HORIZON NUCLEAR POWER LIMITED DEVELOPMENT CONSENT ORDER

EN010007

RESPONSE BY NATIONAL TRUST

ISSUE: NATIONAL TRUST LAND

Scale	As Shown	Sheet Size	A0	(Sheets)	1 of 1
Drawing Number	WN0902-HZDCO-LPN-DRG-00002	Rev	3.0

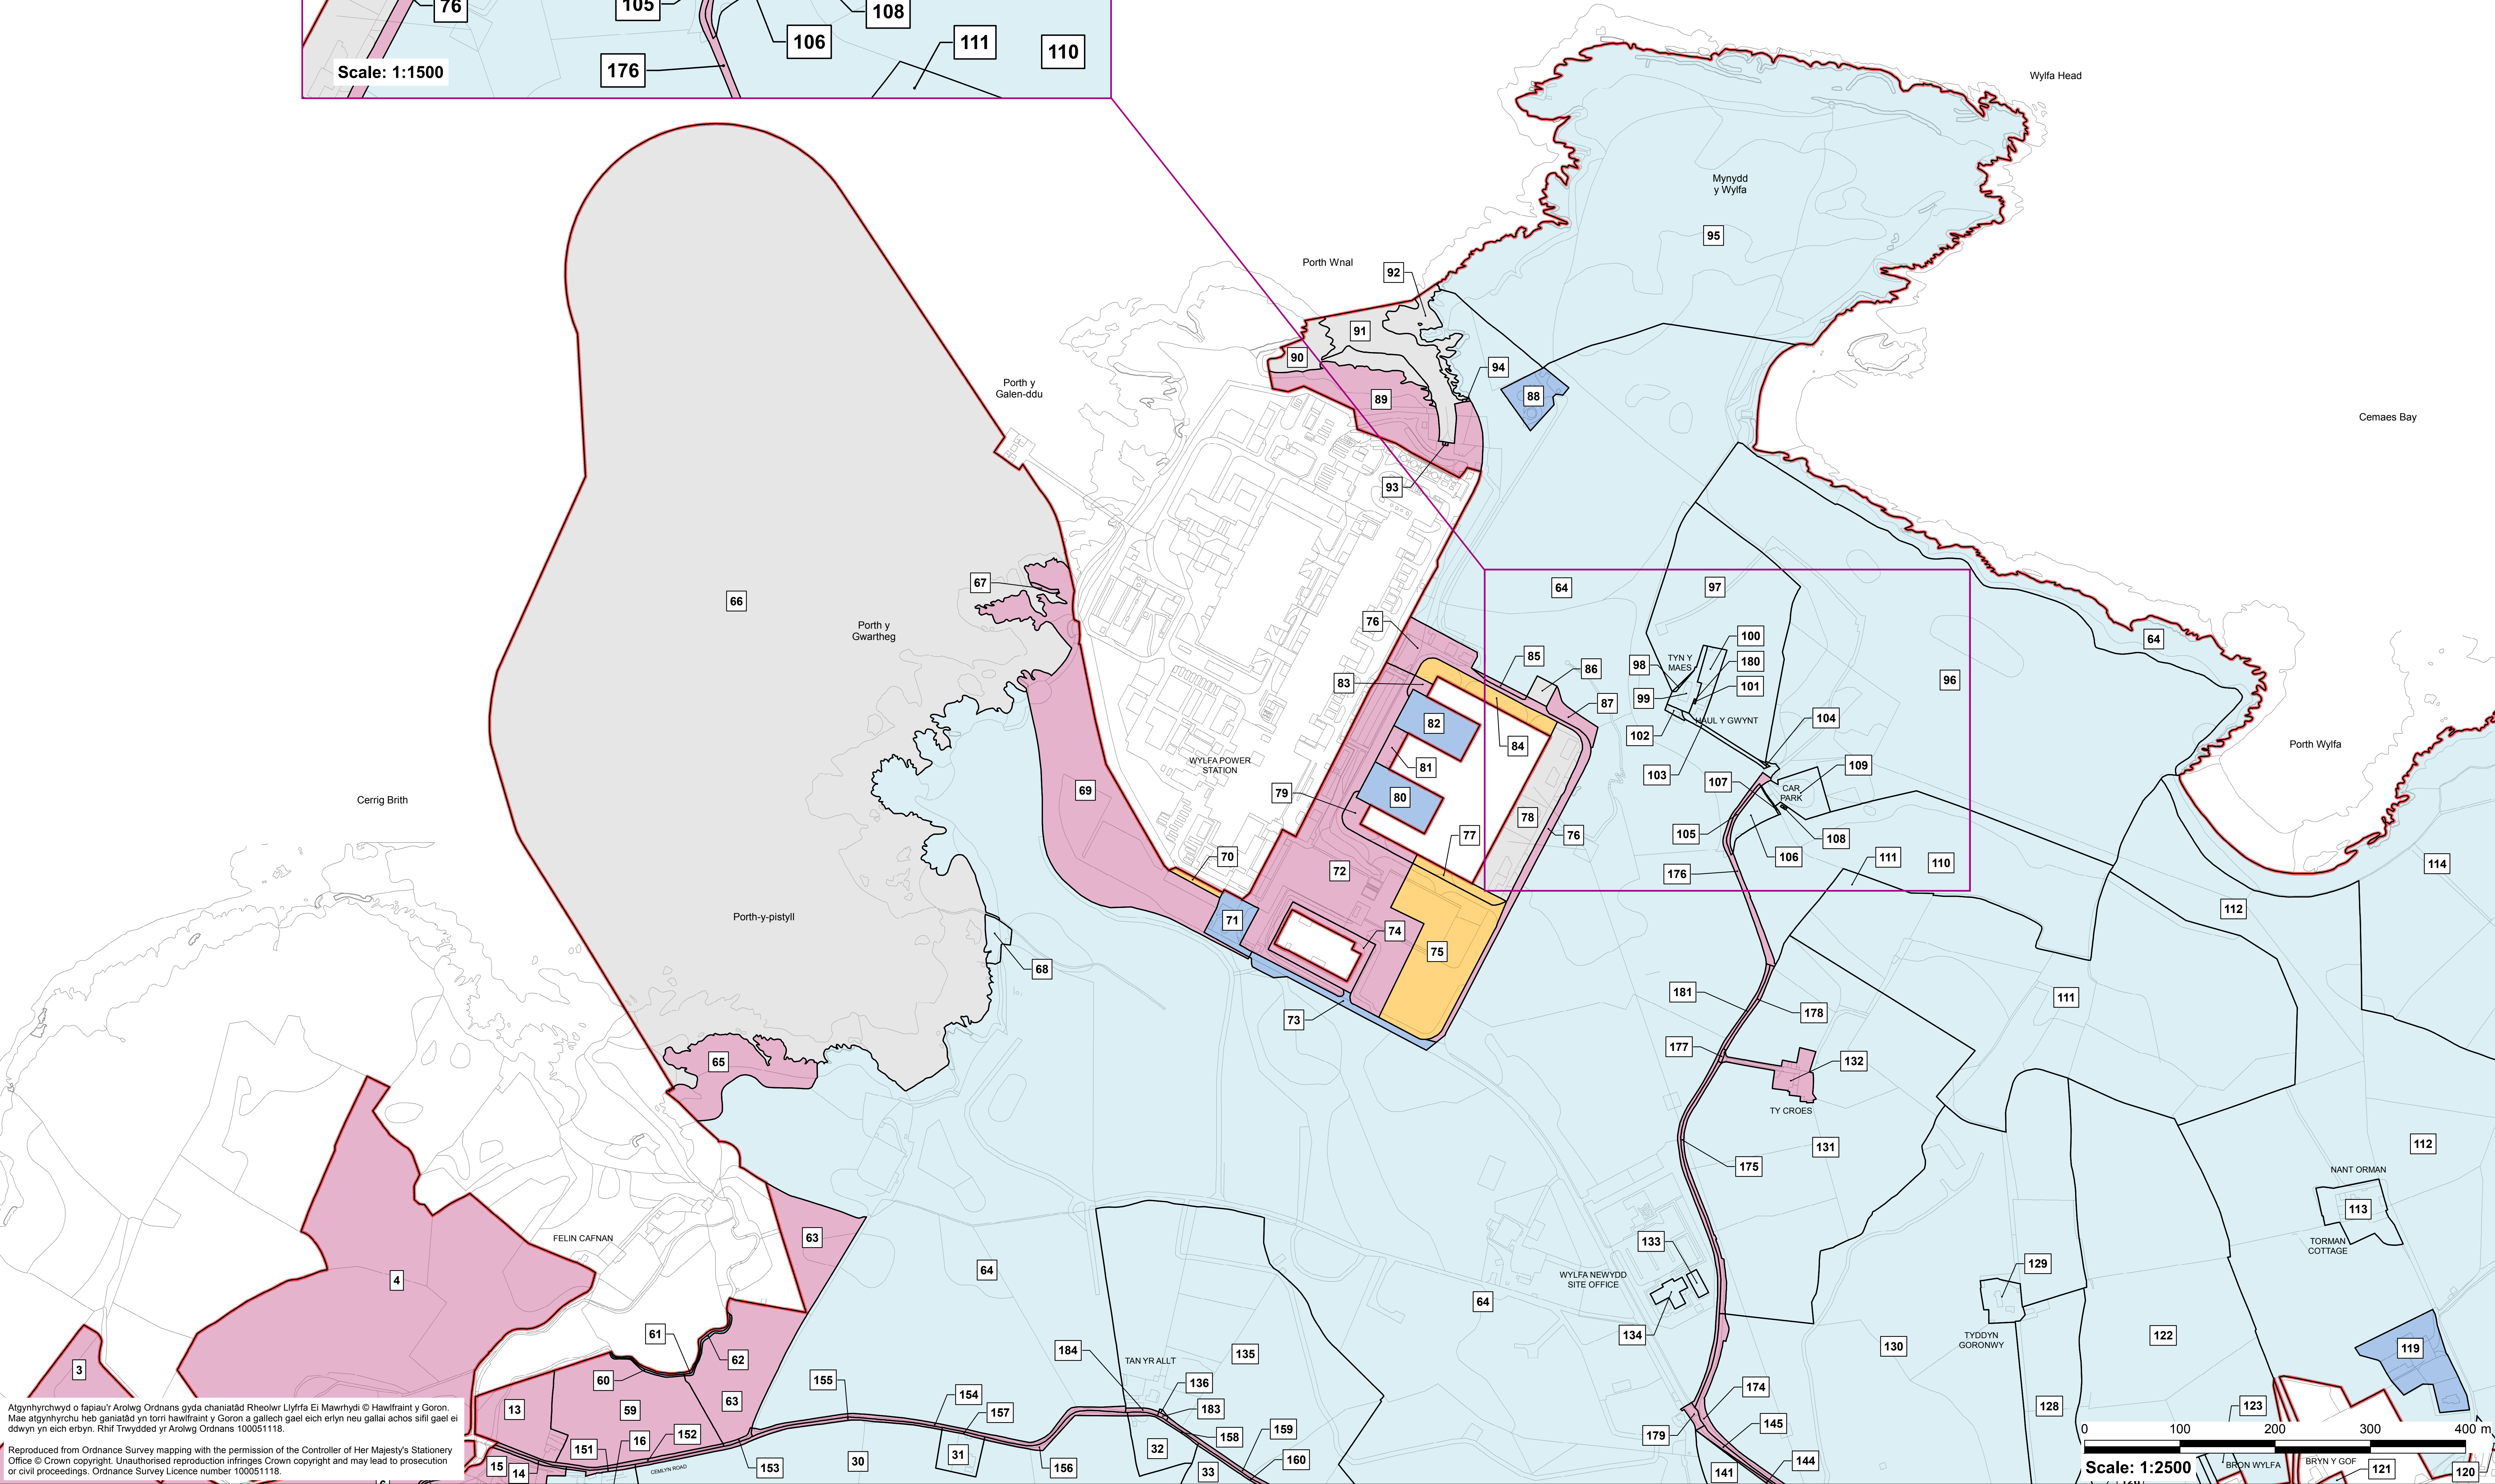
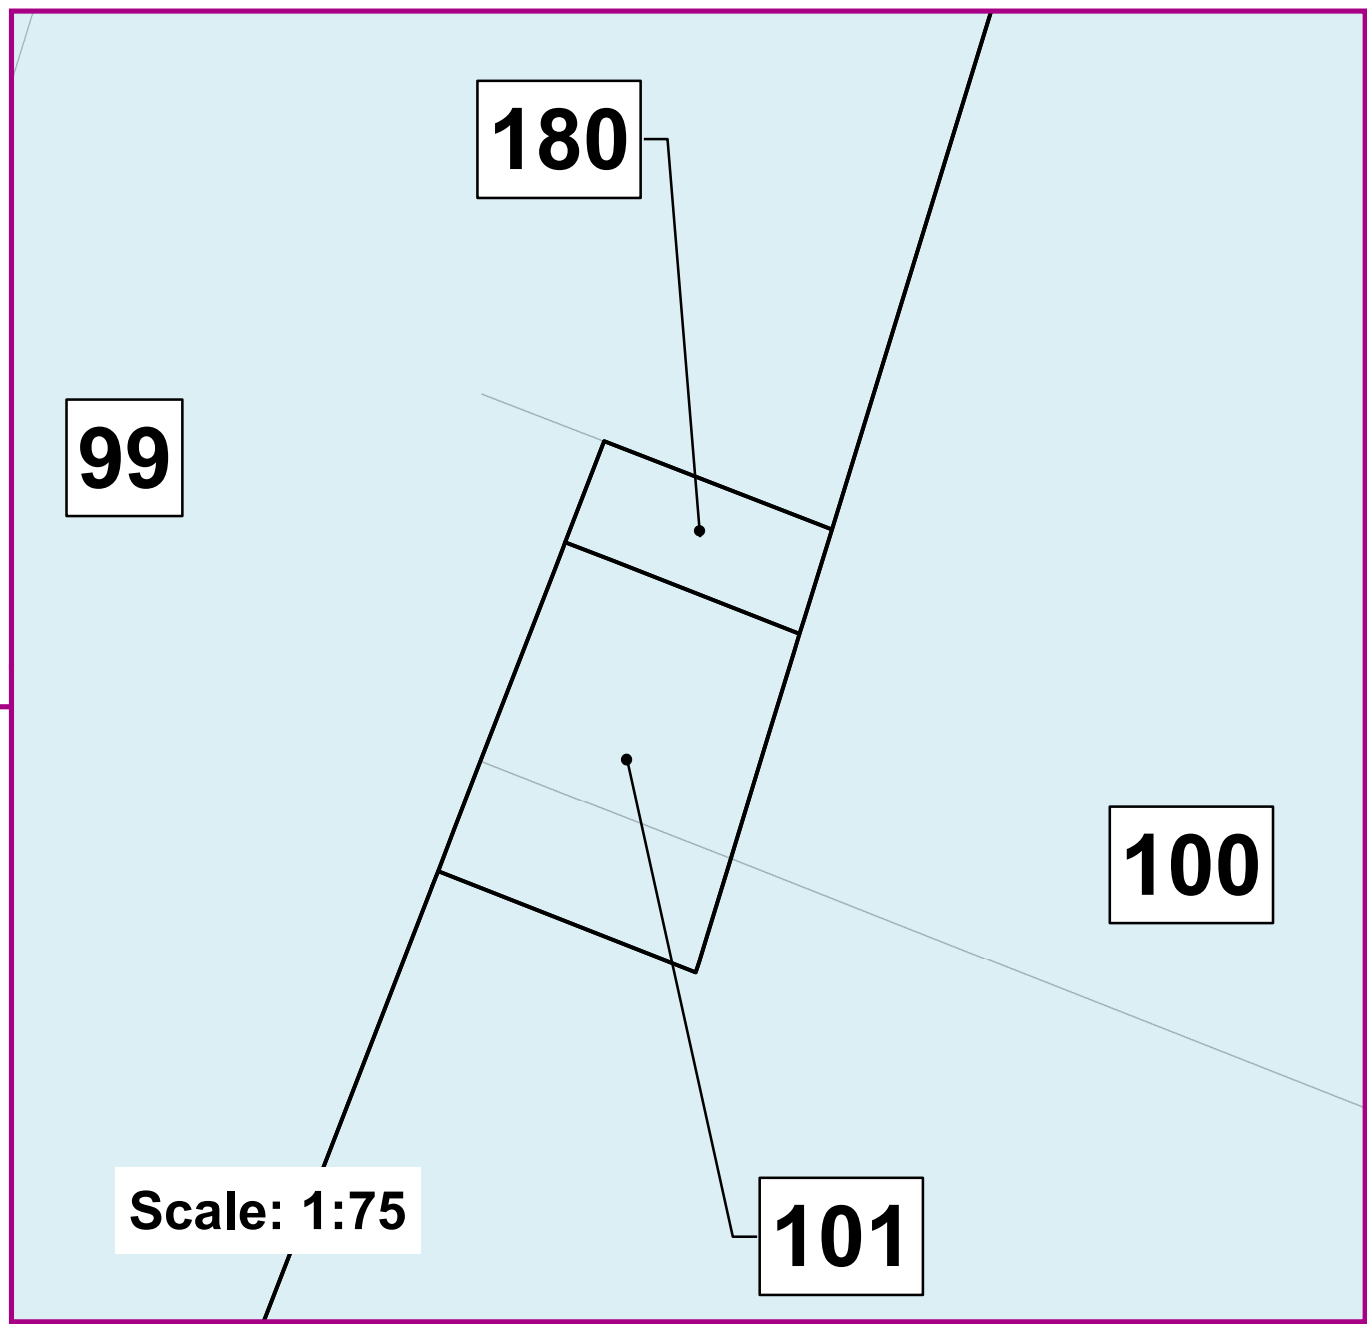
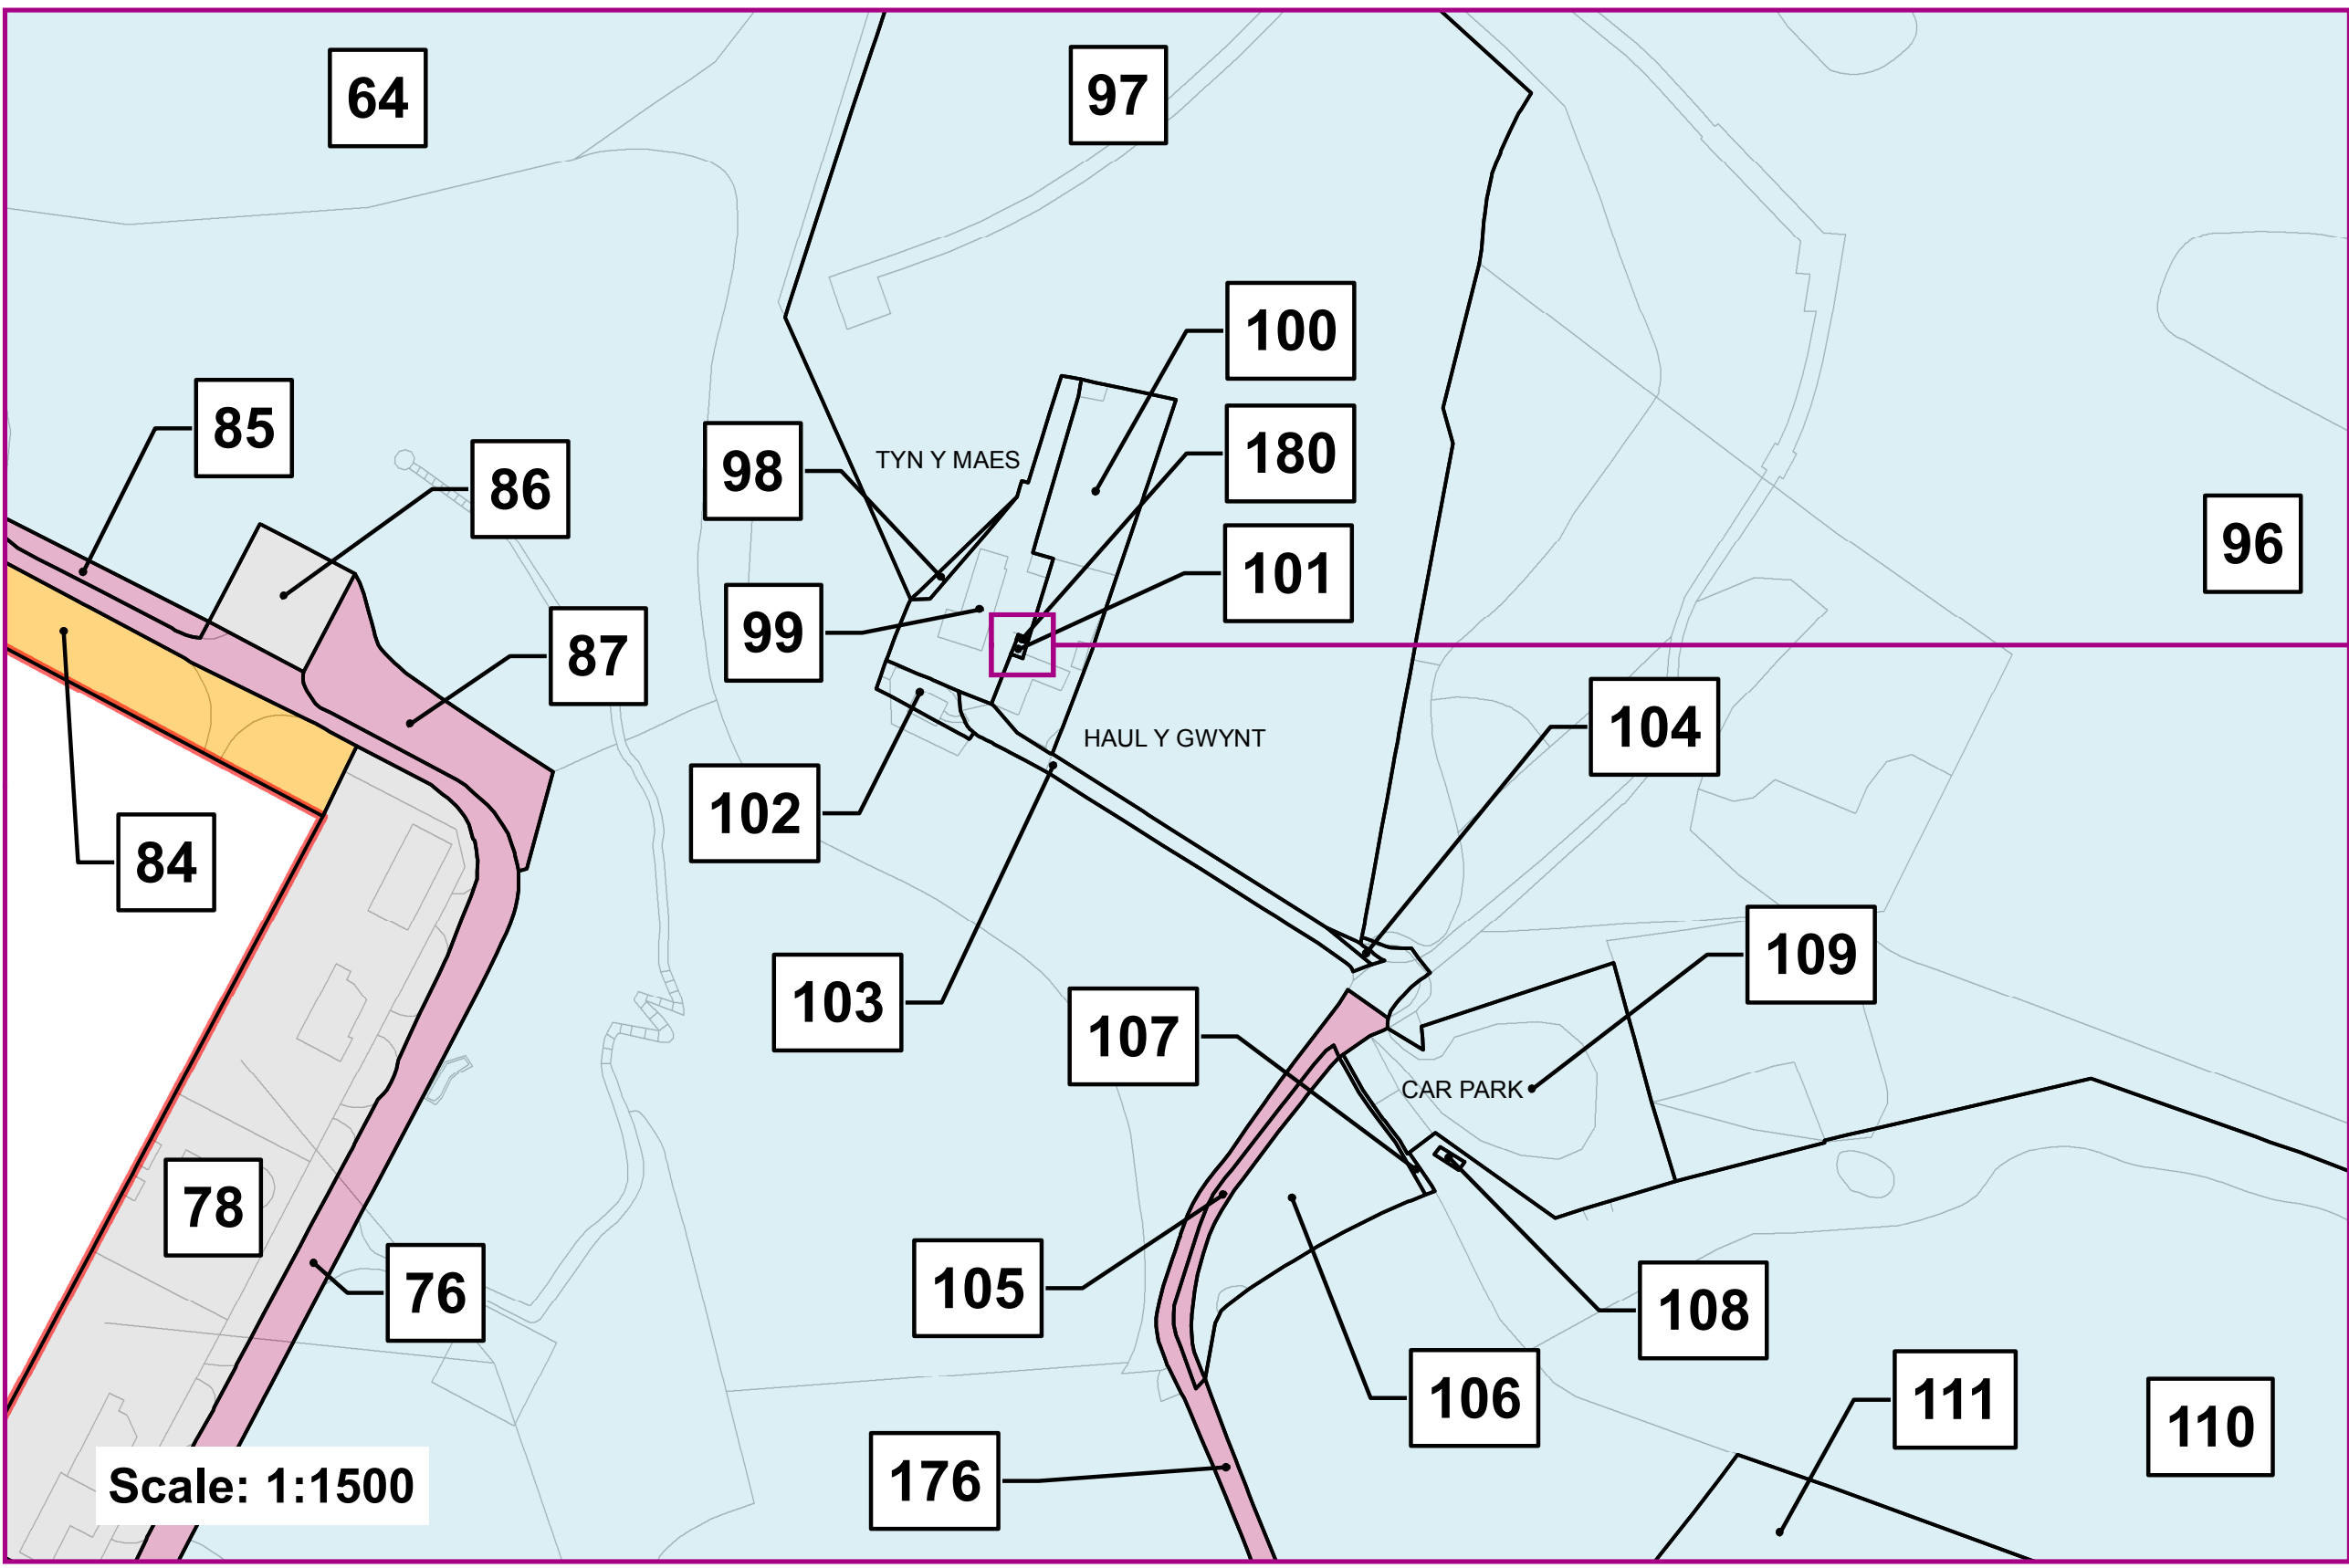
11. However, in addition to the five usual classes of land, the Book of Reference includes "Class 6" which is described in paragraph 7.2.6 of the Book of Reference as "Land that is not subject to powers of acquisition (shown in grey on the land plans)". In Part 1 of the Book of Reference Plot No. 61 is, under "Interest / Right to be Acquired", described as "Class 6". Moreover, it is shown coloured grey in the inset of drawing number WN0902-HZDCO-LPN-DRG-0002 and the legend to that plan states that grey is "land not subject to powers of acquisition".

12. Part 1 of the Book of Reference and the drawing mentioned above suggest that Plot No. 61 is not to be subject to acquisition.
13. In an email dated 7 September 2018 to the Trust, Horizon stated that "[Plot No.61] is included in the book of reference because it was initially believed at

15. None of these tests can be met in the instant case where the scheme's promoter has acknowledged that the land is not required for the project. Since the land is not needed and the section 122 cannot tests cannot be met, all references to the Trust's land which forms Plot No. 61 should be removed from the application documents.

16. Horizon state in the latest version of the Statement of Common Ground ("SOCG") that they intend to "remove Plot 61 from the Order Limits and submit a final Book of Reference and plans at Deadline 10". Since Deadline 10 is not until after the Compulsory Purchase hearing, the Trust will maintain its objection to the acquisition of its land forming Plot No. 61 until it has received a satisfactory assurance that the land in question will be removed from the application documents.

the consultation stage that the land was required and so has been included in the Order limits. However it is now no longer required and is described in the book of reference as Class 6 land which is land not subject to powers of acquisition". So, Plot 61 is not required by Horizon.
